PUBLIC WORKS DEPARTMENT

February 16, 2023

Re: **Sunnyside Village Cohousing – PA 22-042 – Concurrency Recommendation**

### 66TH AVE TYPICAL SECTION

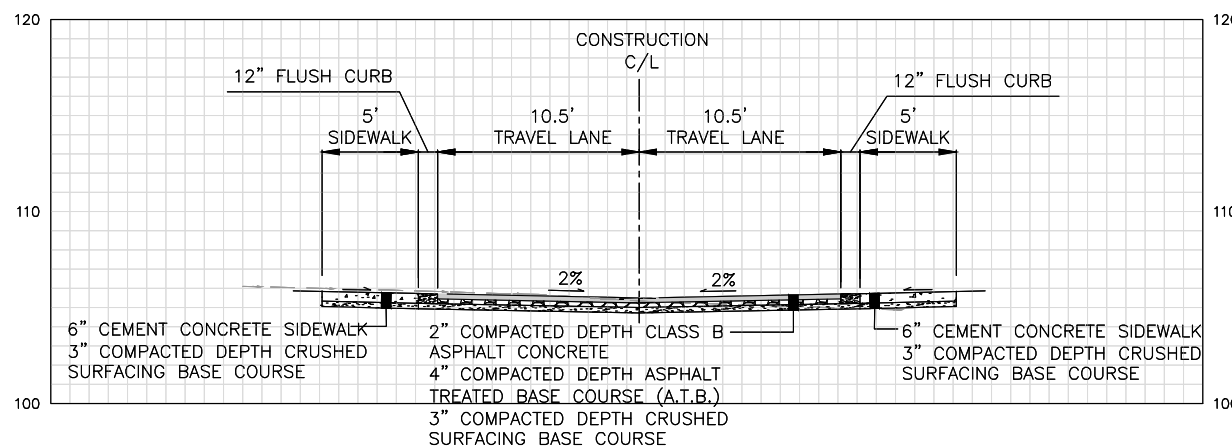
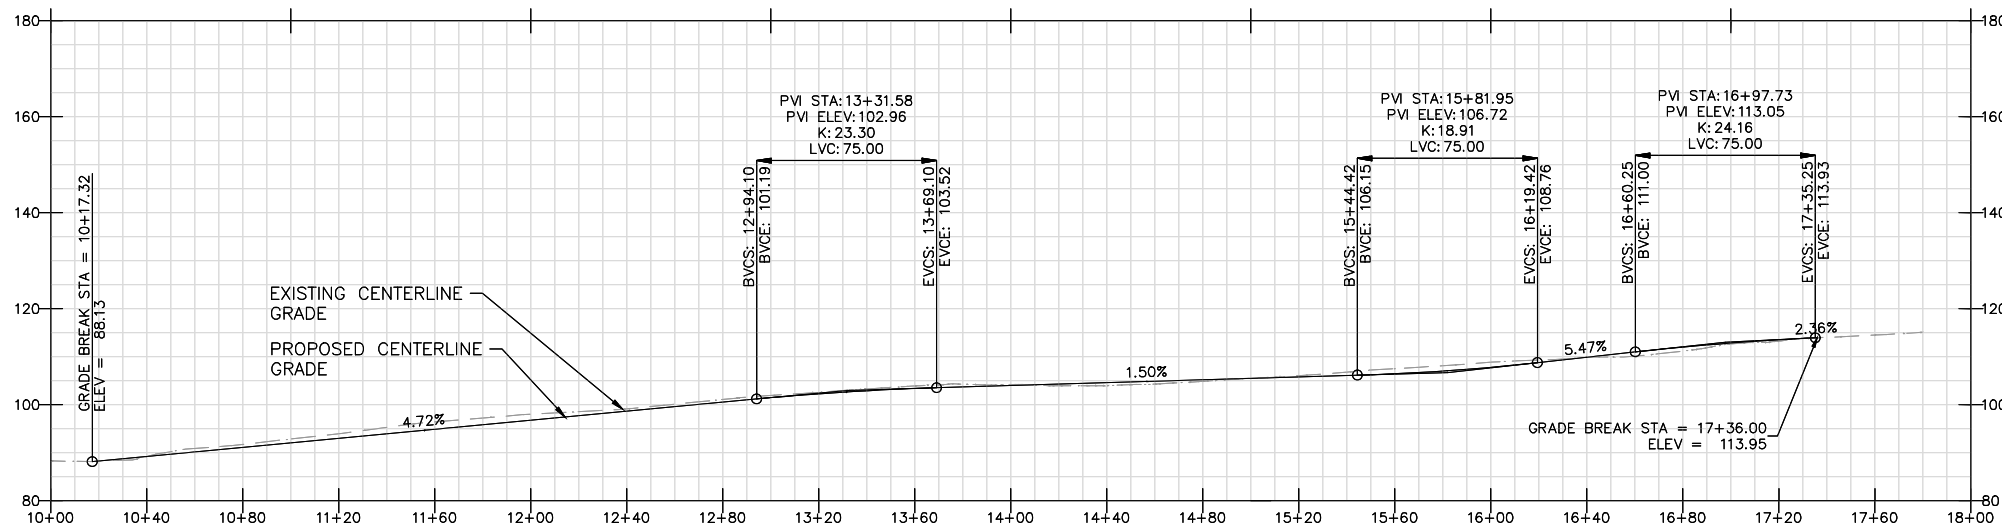
1. The applicant shall be required to construct frontage improvements along 66th Ave NE, prior to final plat approval. Roadway improvements, channelization, site access and lighting plans shall be required to be reviewed and approved by the City Engineer, prior to construction plan approval.

- 1.1. 66th Ave NE is classified as a local access street and is to be built compliant with SP 3-202-002 of the EDDS.
2. The applicant shall be required to dedicate public right-of-way for the extension of 66th Ave NE in accordance with MMC 12.02A.110(1)(c), *Dedication of Road right-of-way – Required setbacks*. Right-of-way widths and required dedication shall be determined by the City Engineer.

- 2.1. The extension of 66th Ave. NE requires a 50 ft. dedication, which is currently shown on the supplied documents.
3. In order to mitigate impacts upon the future capacity of the road system, the applicant shall be required to submit payment to the City of Marysville, on a proportionate share cost of the future capacity improvements as set forth in MMC 22D.030.070(3), for the development. **Traffic impact fees shall be vested at a rate of \$6,300.00, per PMPHT, totaling \$195,300.**
